REQUEST

Current Zoning: CC, LWPA (commercial center, Lake Wylie Protected Area)
Proposed Zoning: CC SPA, LWPA (commercial center site plan amendment, Lake Wylie Protected Area)

Approximately 26.59 acres located in the southeastern corner of the intersection of Rhyne Road and Mount Holly Road.

The petition proposes to amend petition 2008-125 to allow the development of up to 336 apartments on vacant land.

RZ-1.0

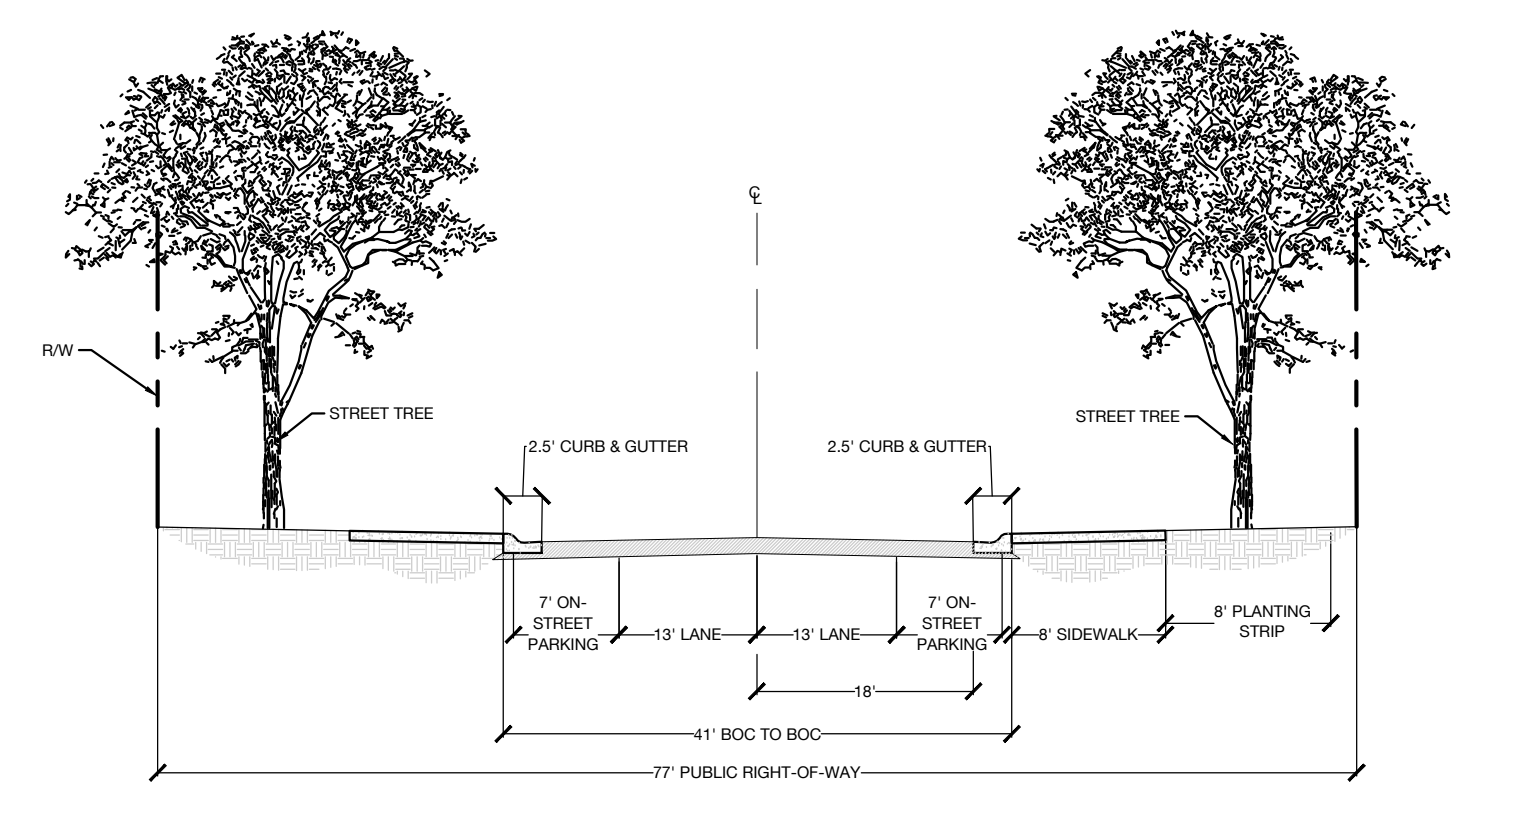
1. ~~Revise building locations to be in compliance with setbacks as stated in Section 9.303(19)(e).~~ **ADDRESSED**
2. ~~Revise building orientation to limit the number of side facing buildings as they relate to the Public Road 1.~~ **ADDRESSED**
3. ~~Revise Architectural and Design Standards note 4.b to replace the word "or" with "and" and "may" with "shall" as specified in the site plan comments.~~ **OUTSTANDING**
4. ~~Revise the rear yard from 25' to 40' as specified in site plan comments.~~ **OUTSTANDING**
